**Waitara Public School Redevelopment, 48-58 Myra Street, Wahroonga (SSD 8574)
Notice of Exhibition**

Thank you for your letter dated 26 March 2018, requesting Transport for NSW (TfNSW) review and comment on the above.

**Indicative construction
traffic management plan**

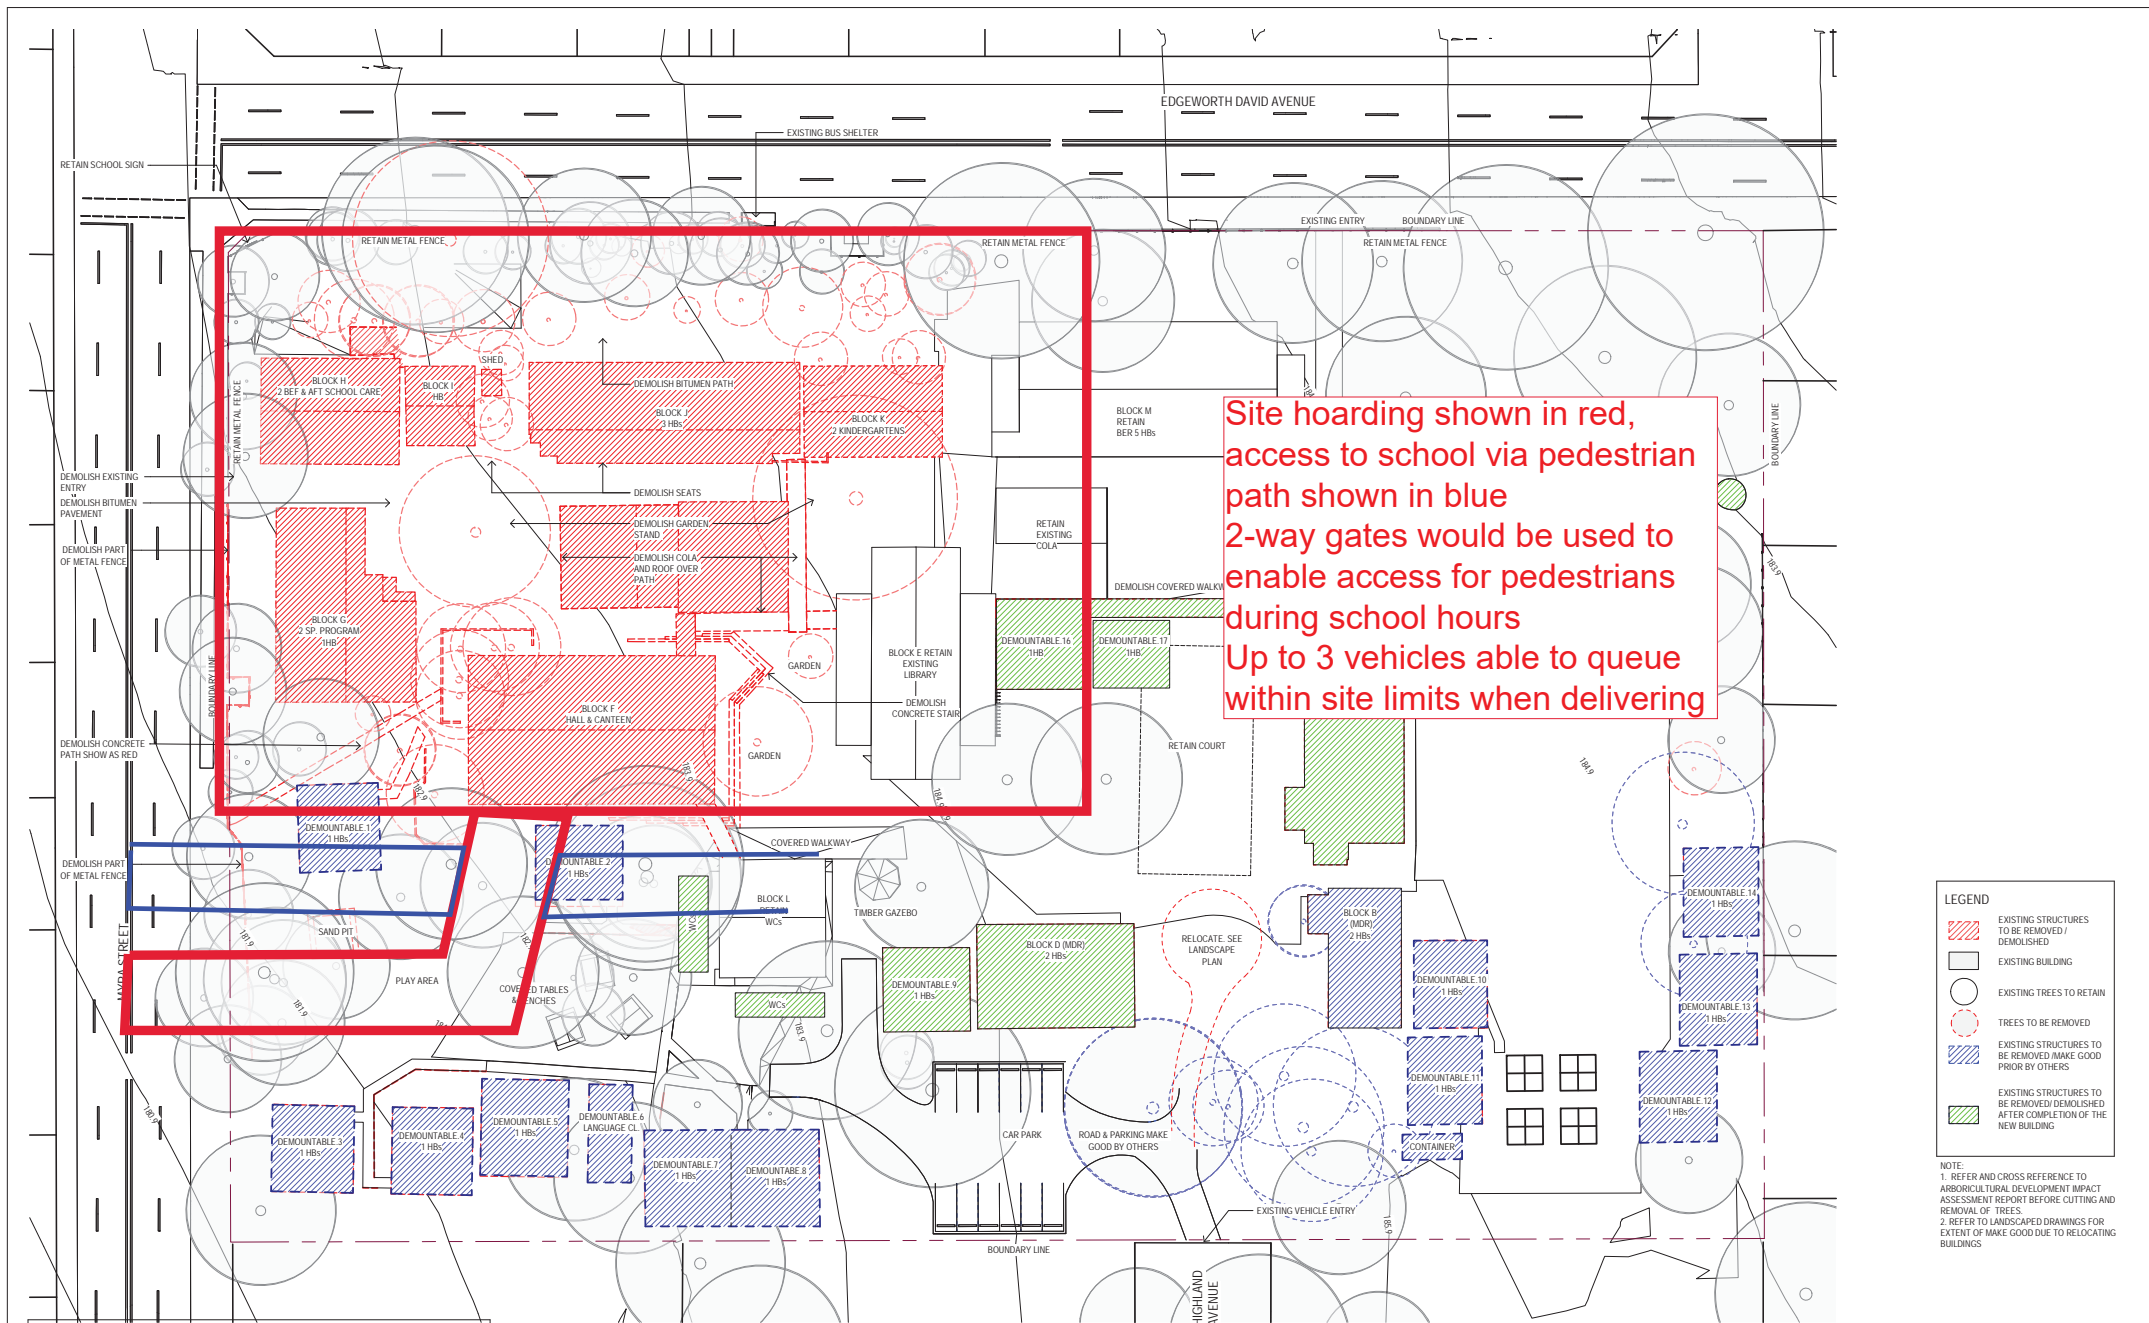
Construction activities for the expansion of the school are expected to occur while students are on site. In addition, construction vehicle movements from the development could have the potential to impact on general traffic and bus operations within the vicinity of the School, as well as the safety of pedestrians and cyclists particularly during commuter peak periods.

- Location of the proposed work zone
- Haulage routes;
- Construction vehicle access arrangements;
- Proposed construction hours;
- Proposed measures to prevent students accessing the construction area;
- Estimated number of construction vehicle movements;
- Construction program;
- Any potential impacts to general traffic, cyclists, pedestrians, students and bus services within the vicinity of the site from construction vehicles during the construction of the proposed works;
- Cumulative construction impacts of projects within the vicinity of the proposed development; and
- Proposed mitigation measures. Should any impacts be identified, the duration of the impacts and measures proposed to mitigate any associated general traffic, public transport, pedestrian, students and cyclist impacts should be clearly identified and included in the CPTMP.

It is requested that the applicant be conditioned to prepare a Construction Pedestrian and Traffic Management Plan (CPTMP), in consultation with Hornsby Shire Council and Roads and Maritime Services, with specific reference to but not limited to:
